Your Ref: OWPC24306
Our Ref: M/73/19/HH 06-08-2019
Please ask for:
Zac Denton

Town & Country Planning Act 1990 (as amended)
Town & Country Planning (Development Management Procedure) (England) Order 2015

Erection of a single storey outbuilding to be used as a washroom/garden studio
7 Sea Way Middleton-On-Sea

Garden studio & washroom

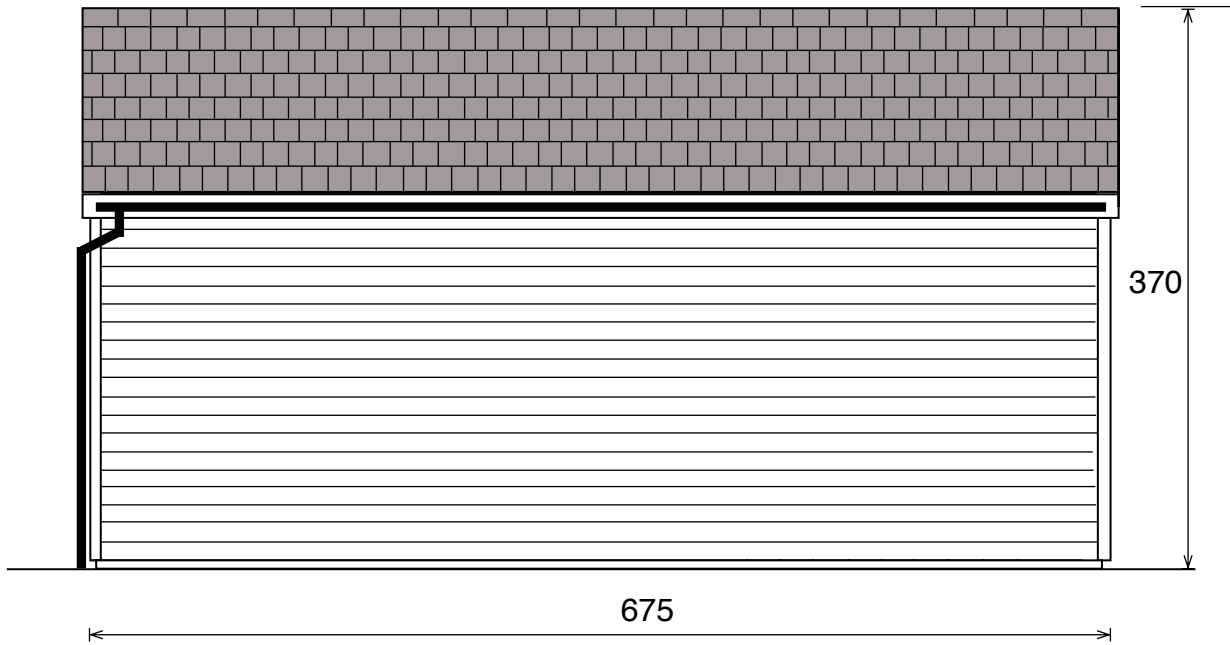
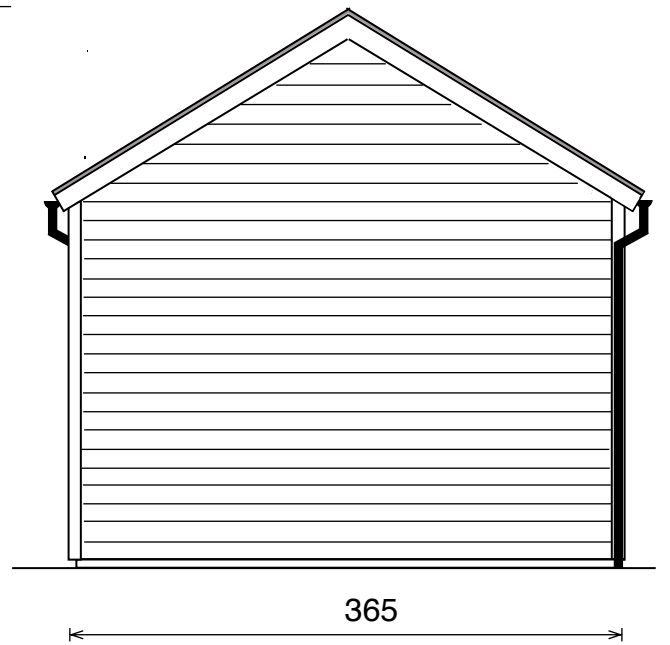
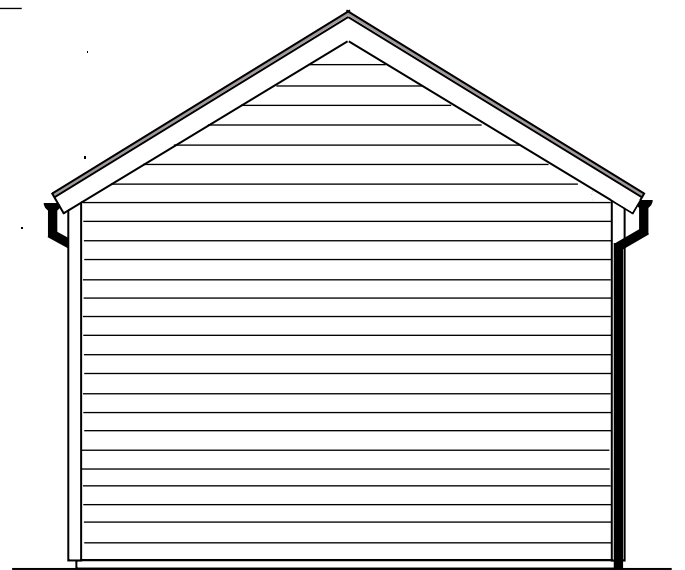
I believe the location of the proposed structure is poorly considered, immediately adjacent to the front wall and the side fence. At 3.7m height it would stand 1.2m higher than the boundary fence and at 25msq it is hardly a garden shed. From my limited knowledge i thought garden outbuildings should have a maximum height of 2.5m. With such a prominent position, next to the road, it would be unsightly and out of character with the local street scene. The materials being proposed are also out of character with the local environment. Large outbuildings, should be consigned to rear gardens, out of sight to neighbours and the general public. Maybe an extension to the side or rear of the property, in keeping with the design and materials of the main building, could be considered....am sure this would meet with a more favourable response.
